**Re: Back Porch**  
**1212 – 1210 – 1208 Rio Grande NW Albuquerque NM 87104**  
**Traffic Circulation Layout**  
Engineer's/Architect's Stamp 08-20-18 (H13-D110)

Mojgan Maadandar  
Associate Engineer, Planning Dept.  
Development Review Services

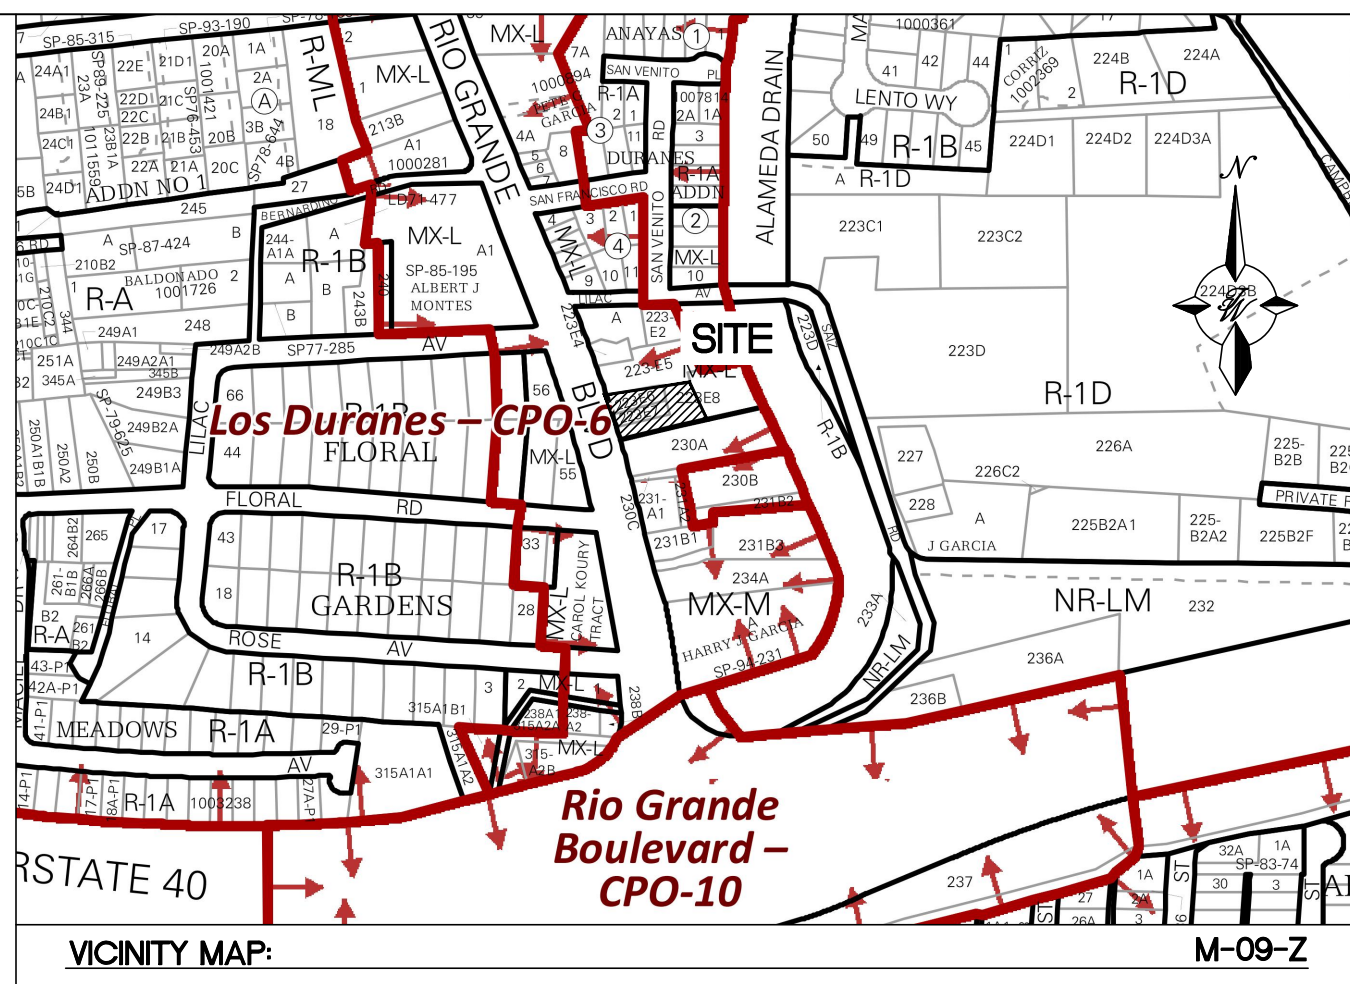
1. Clarify existing property lines and proposed property lines.
2. Please list the width and length for all existing and proposed parking spaces. Some dimensions are not shown.
3. Label the compact parking spaces by placing the words "**COMPACT**" on the pavement of each space.
4. The ADA accessible parking sign must have the required language per 66-7-352.4C NMSA 1978 "**Violators Are Subject to a Fine and/or Towing.**" Please call out detail and location of HC signs.
5. Motorcycle parking spaces shall be designated by its own conspicuously posted upright sign, either free-standing or wall mounted per the zoning code.
6. Provide shared parking agreement.
7. Provide the thickness of the gravel parking space according to DPM or traffic capacity.
8. Show all drive aisle widths and radii. Some dimensions are not shown.
